From: Martyn White <Martyn.White@arun.gov.uk>
Sent: 28 September 2020 16:35
To: Amy Myer <Amy.Myer@arun.gov.uk>
Subject: LU/218/20/PL & LU/219/20/L

LU/218/20/PL & LU/219/20/L

Flintstone Centre East Street Littlehampton BN17 6AW

Erection of new fencing & gates to the rear & sides of building & removal of wire mesh fencing & gate between the playground & building. This application affects the character & appearance of the East Street Conservation

Status: PROPOSED

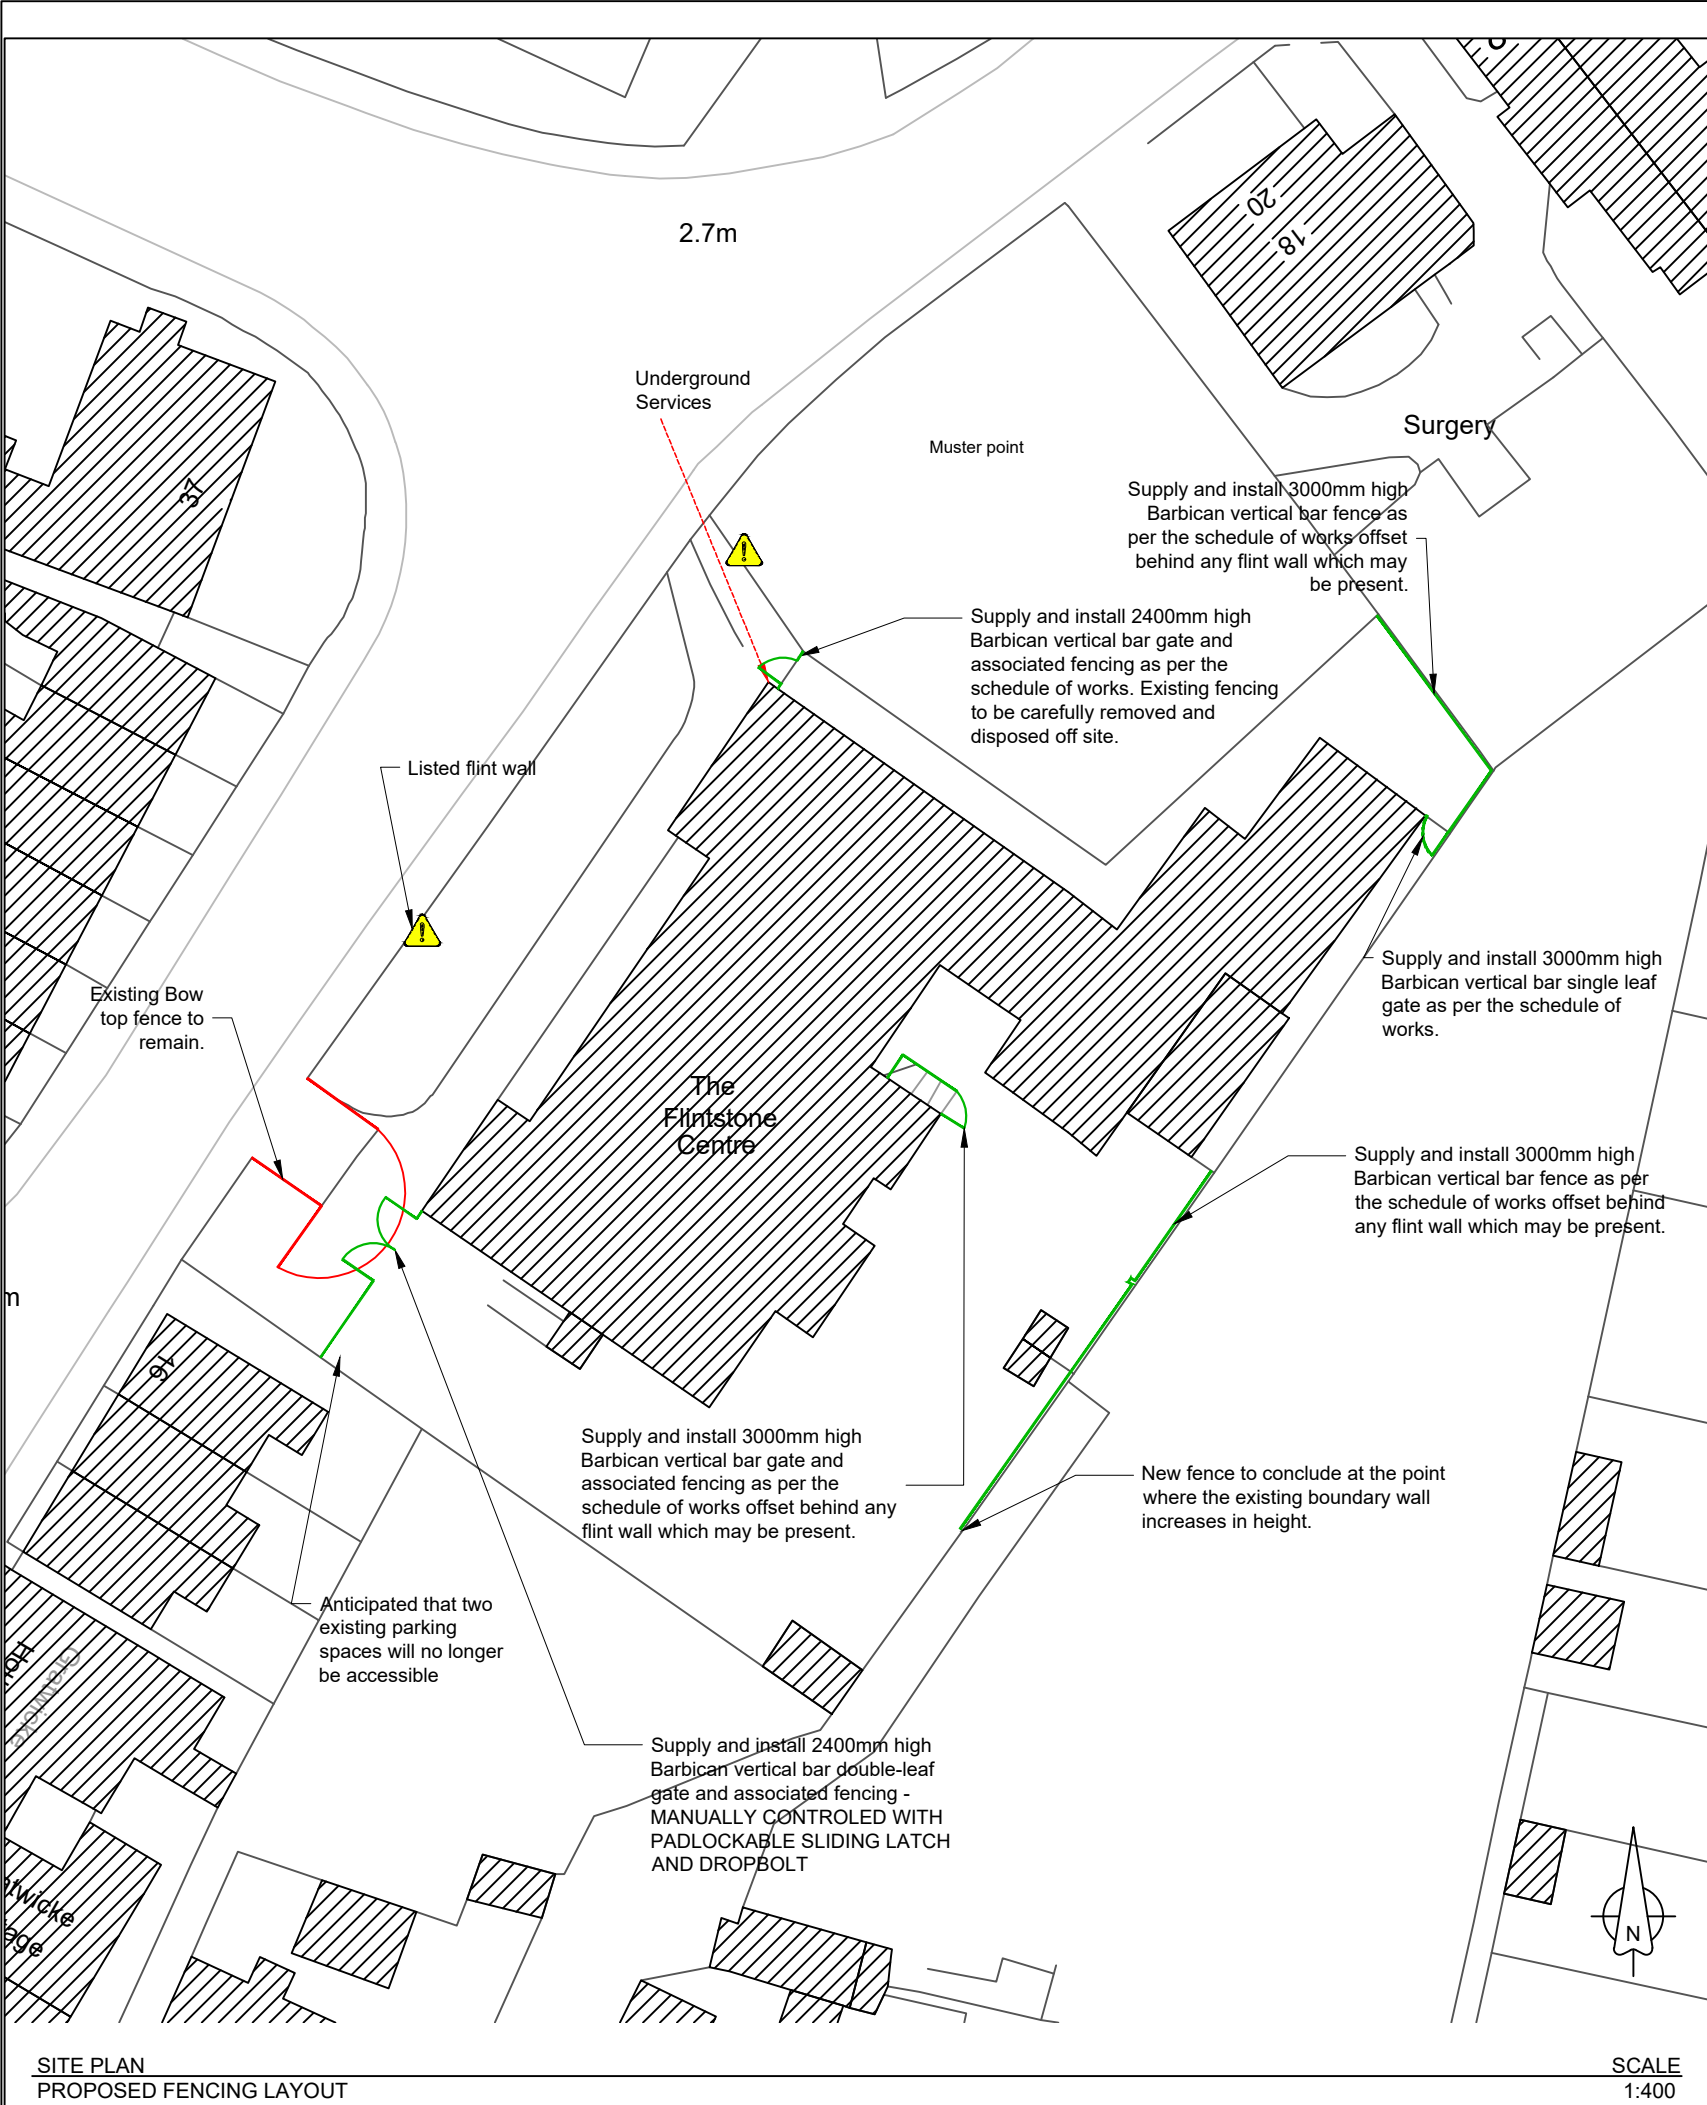
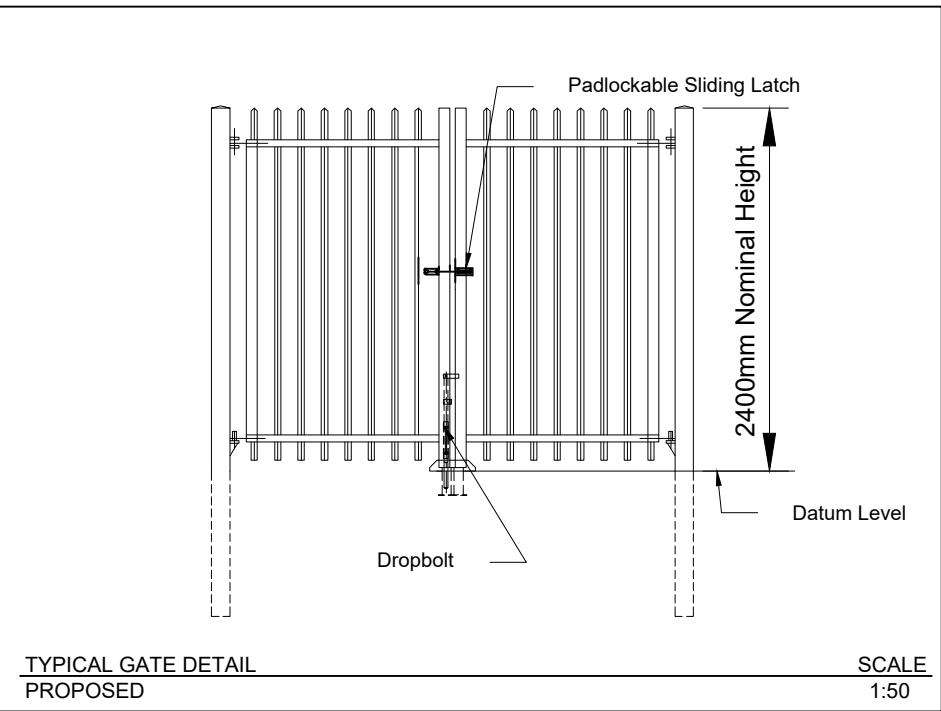
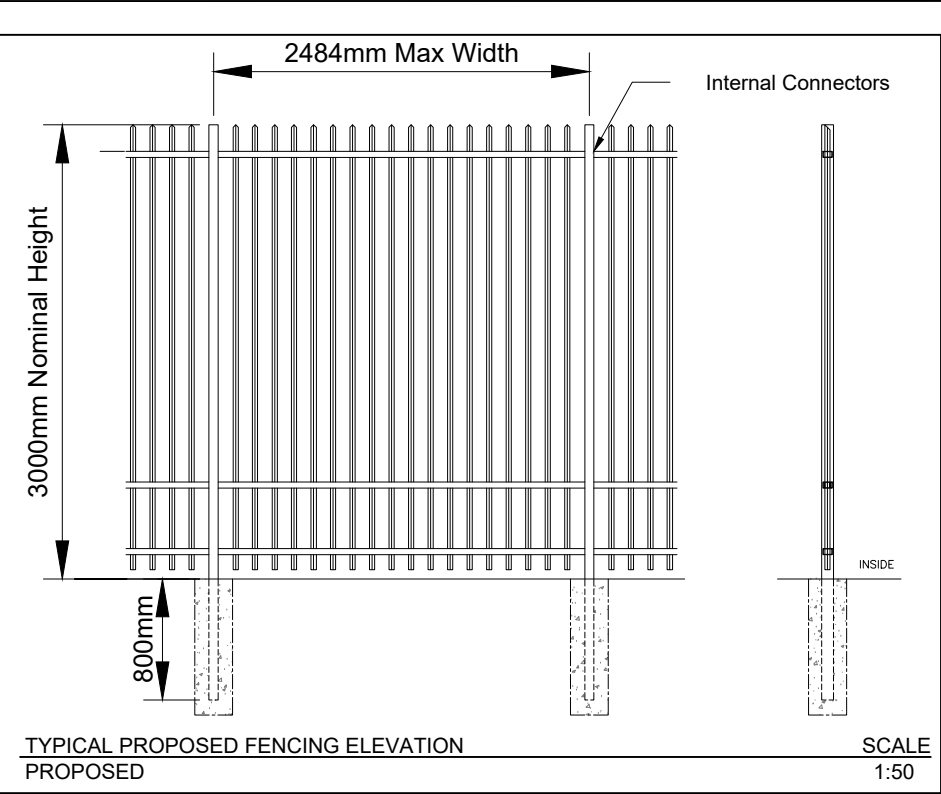
Erection of new fencing & gates to the rear & sides of building & removal of wire mesh fencing & gate between the playground & building. It is assumed that the existing mesh fencing which encompasses the playground will remain. Is this correct?

Of particular note is the element of the fencing which is located in the southern part of the site, and both clearly visible from the street and in the context of the listed building. Its height and appearance are not considered to be appropriate for the heritage asset or local area. It is therefore problematic. Further, it is not clear if any alternate, and more appropriate fencing has been identified or not.
